# CITY OF ALBUQUERQUE

RE: **Sicily Plaza- 6001 Coors Blvd NW**  
**Grading Plan and Drainage Report**  
**Engineer's Stamp Date: 12/7/17**  
**Drainage File: E12D003F**

RE: **Sicily Plaza- 6001 Coors Blvd NW**  
**Grading Plan and Drainage Report**  
**Engineer's Stamp Date: 11/28/17**  
**Drainage File: E12D003F**

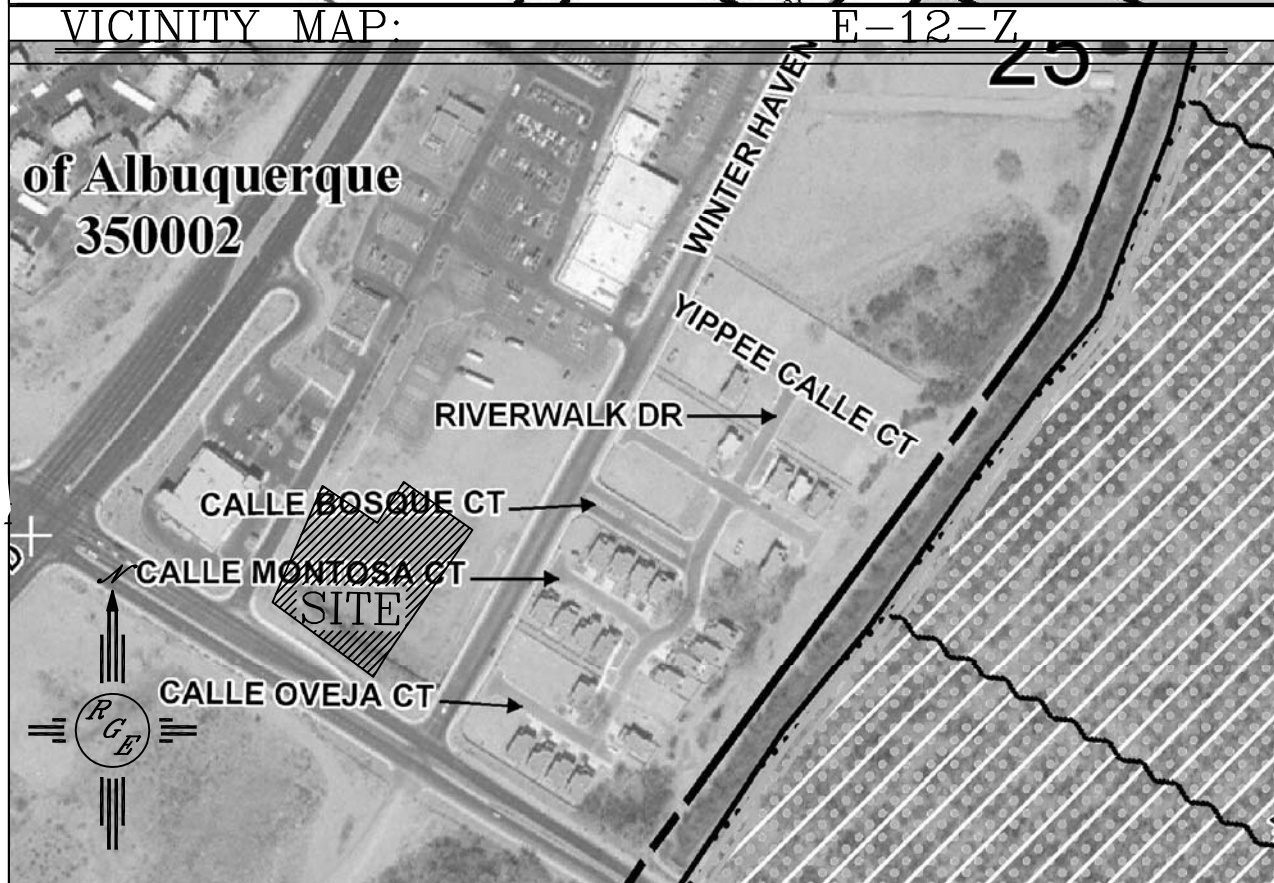
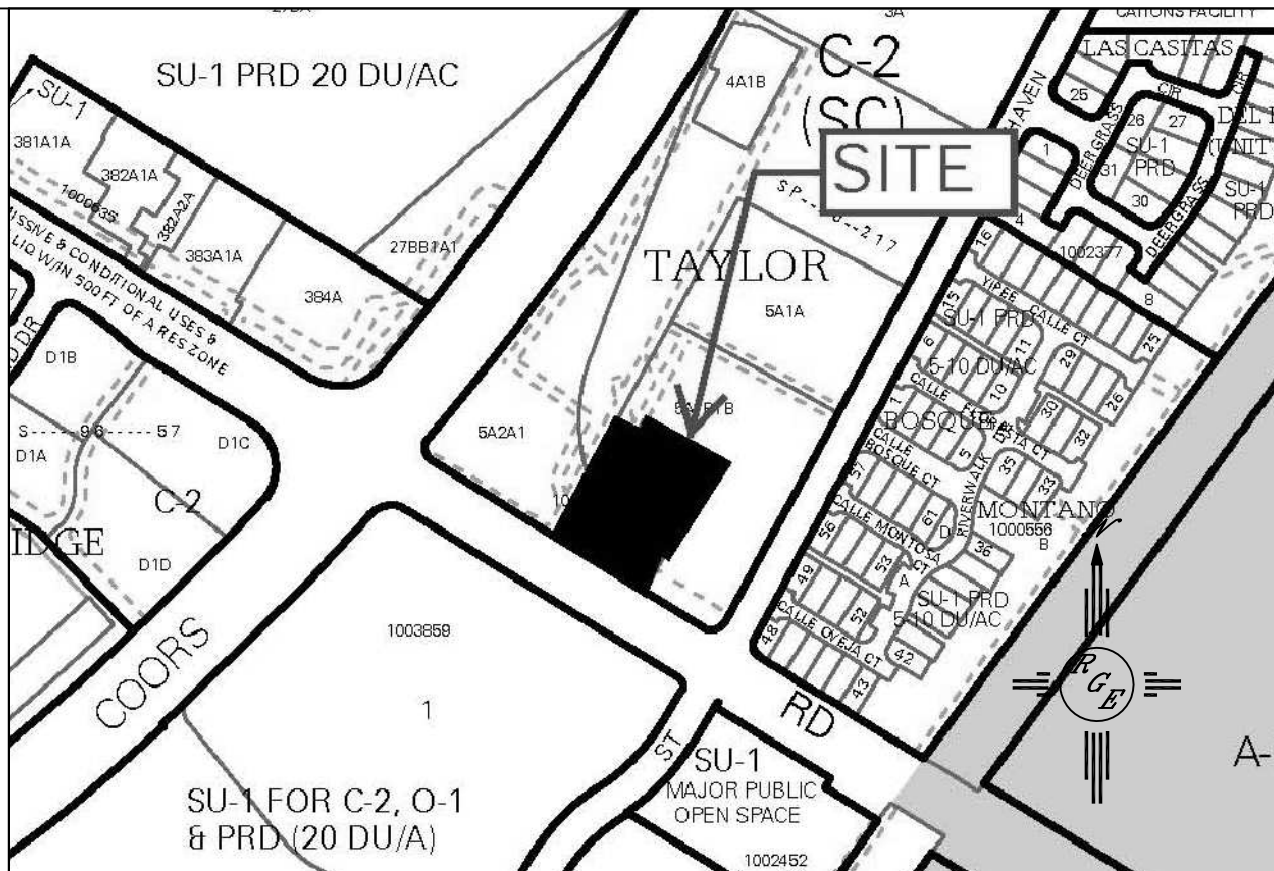
2. Bottom of pond elevation on the new pond needs to be corrected. **WE CORRECTED**
3. Is this a restaurant? If so please provide the utility sheet showing the grease trap and drain line to sanitary sewer for the dumpster. or show this on the grading plan. **THE UTILITY DESIGN IS NOT COMPLETED. WE HAVE ADDED A NOTE**
